From: Neil Crowther
Sent: 04 February 2019 11:16
To: Planning.Responses
Subject: FW: Discharge of Condition 5 BE/18/17/PL - New Barn Lane, North Bersted

Application correspondence BE/117/18/DOC

Subject: RE: Discharge of Condition 5 BE/18/17/PL - New Barn Lane, North Bersted

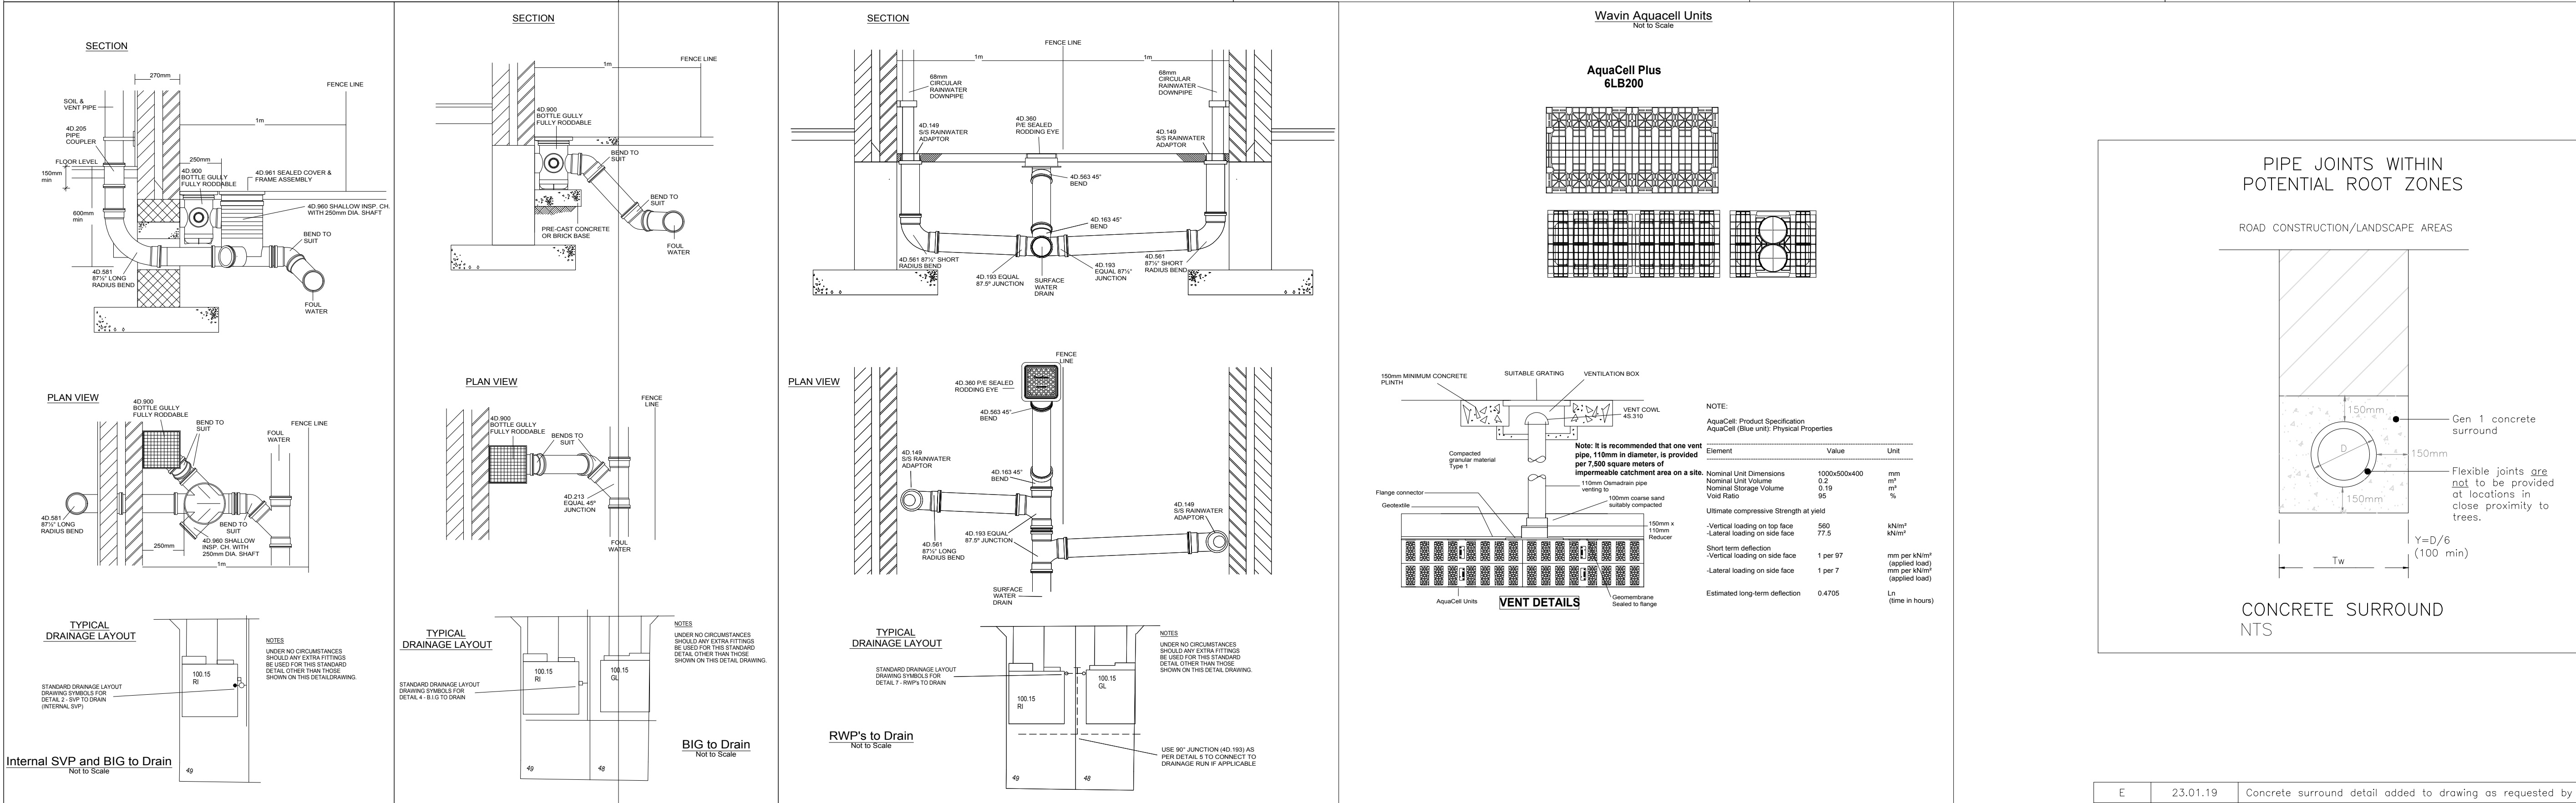
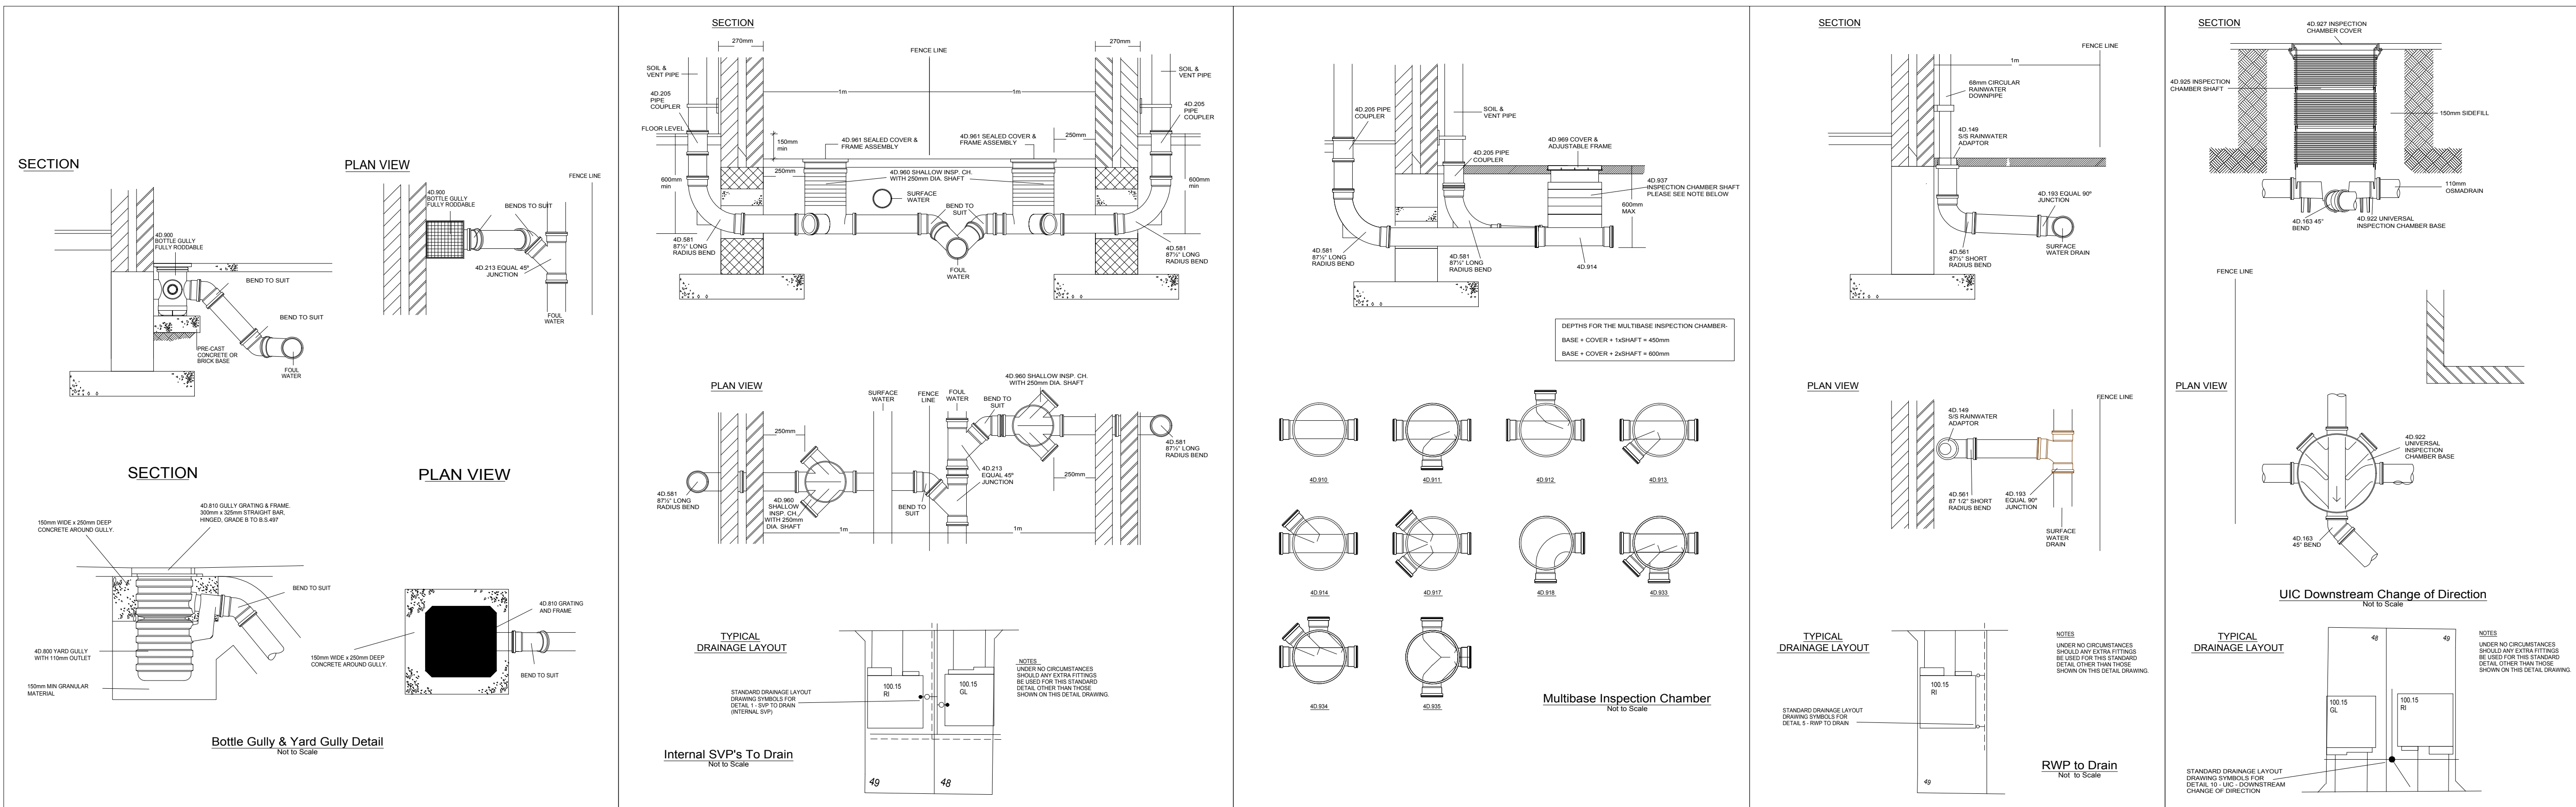
4.150mm concrete bed and surround will need to be provided at all pipes joints within potential root zones.
MJA Response—Notes added to engineering drawings; Can you please send these engineering drawings through.
MJA Response—Concrete surround detail is located in Drawing LMS232-1021 (enclosed); *This concrete bed and surround detail is for standard bedding, it does not state that the flexible joints are not to be provided at locations in close proximity to trees. Can you please add a specific detail and note to a surface water sewer construction detail sheet.*
MJA Response—Noted, concrete surround detail added to Drawing LMS232-1022 revision E; Okay.

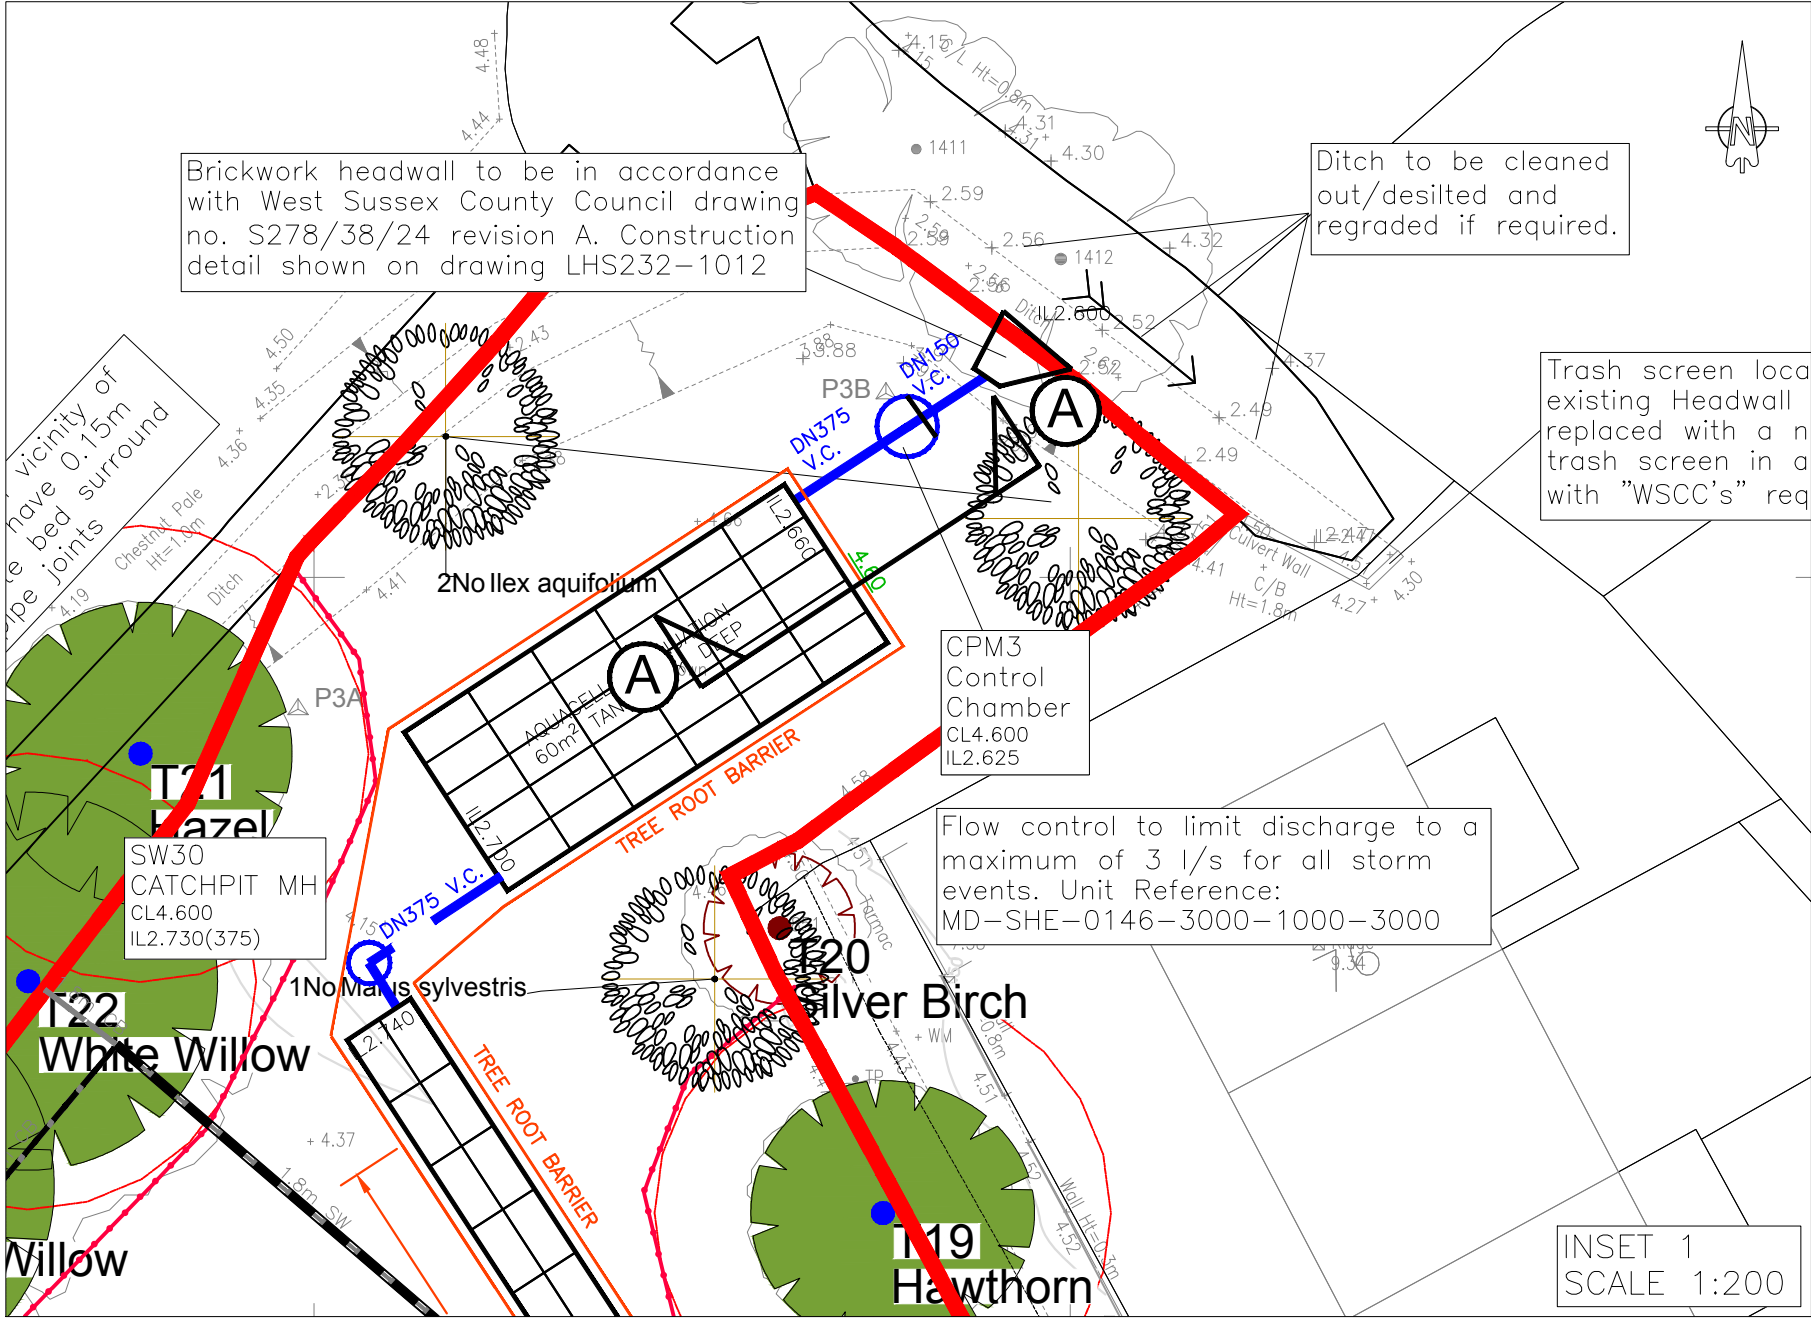
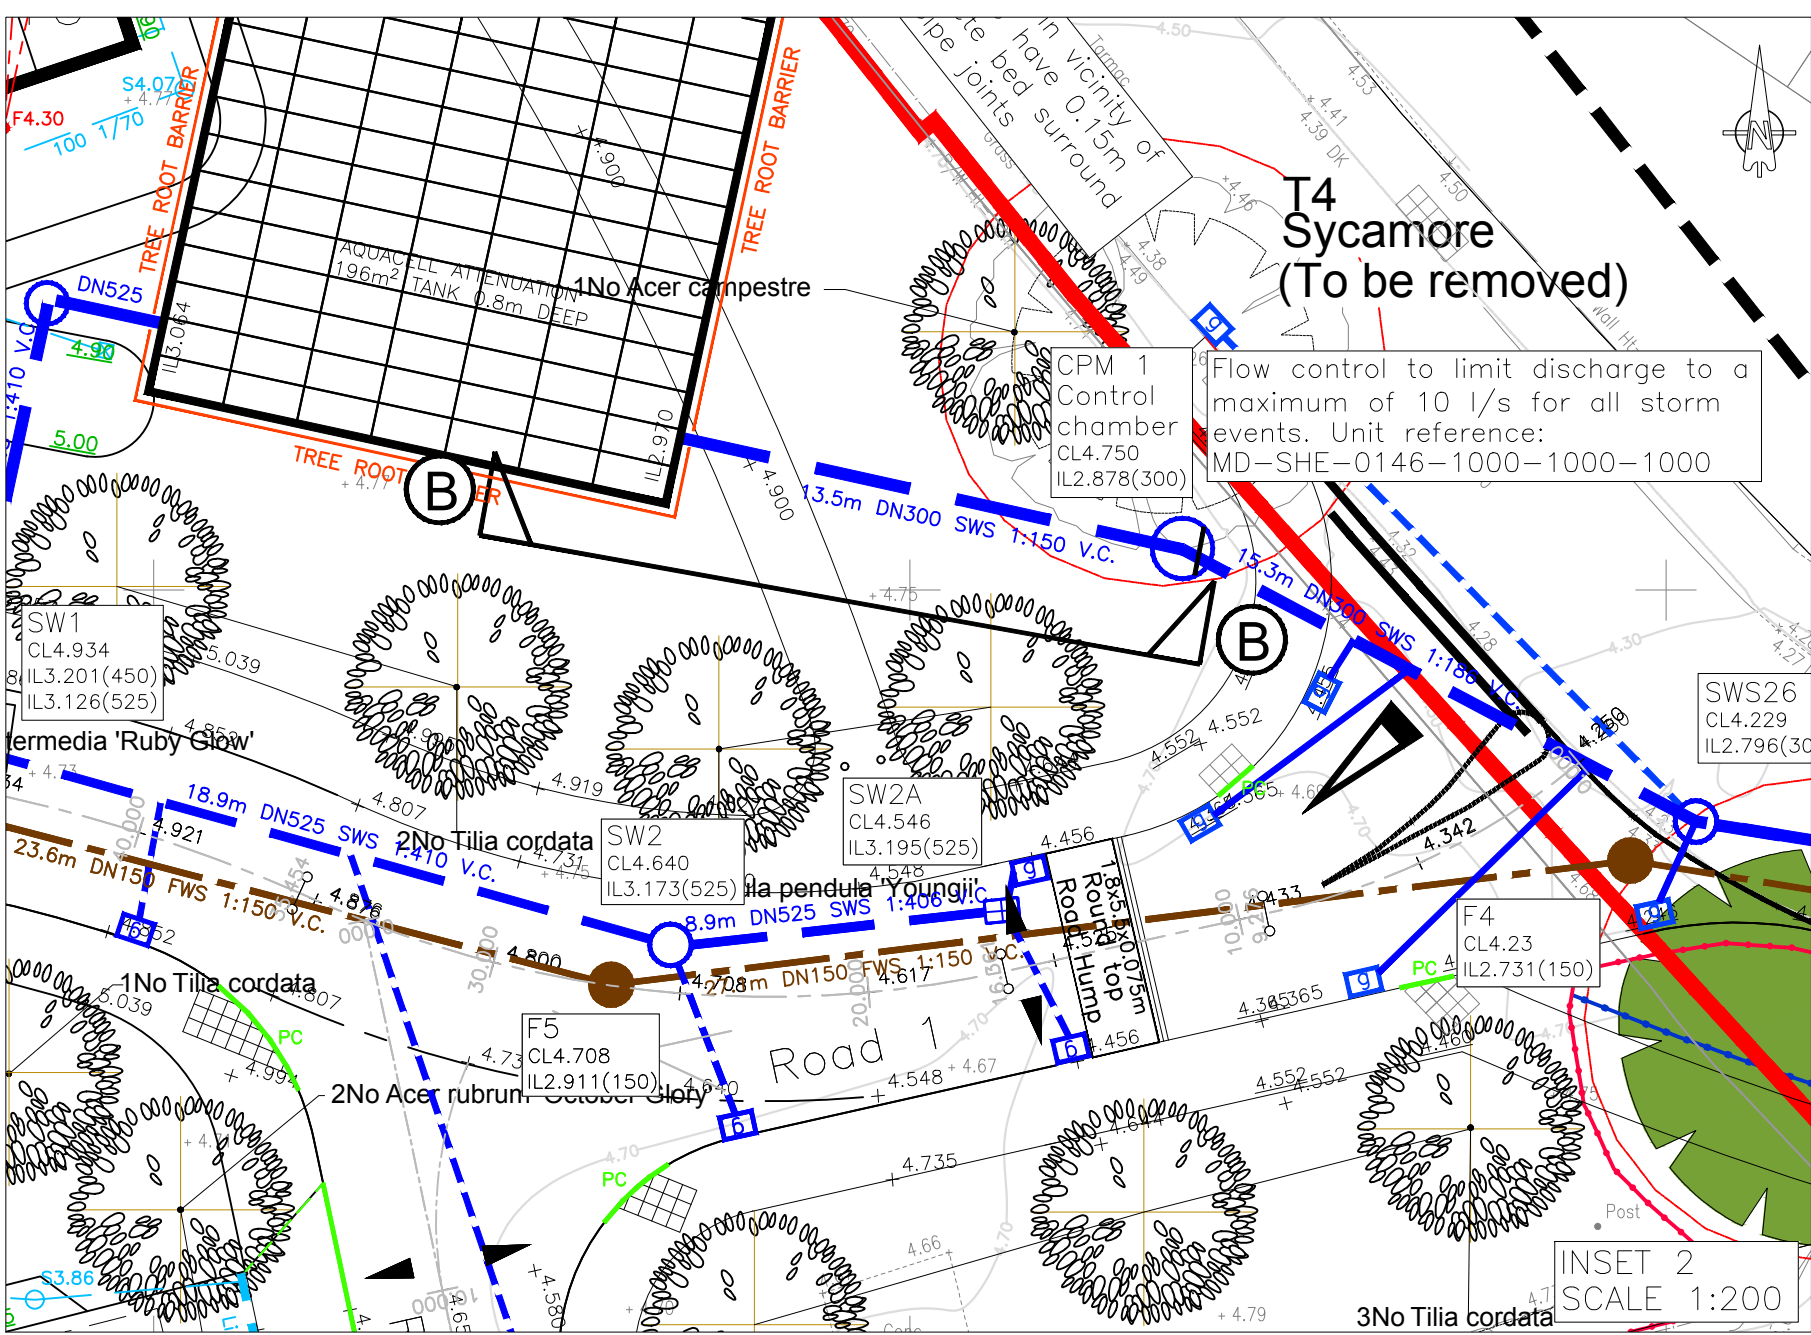
5. Please supply uplift calculations for the attenuation tanks with submission.
6. Please can you provide an update regarding the ordinary watercourse land drainage consent. Without this you cannot implement the scheme and therefore will not be able to comply with the condition.
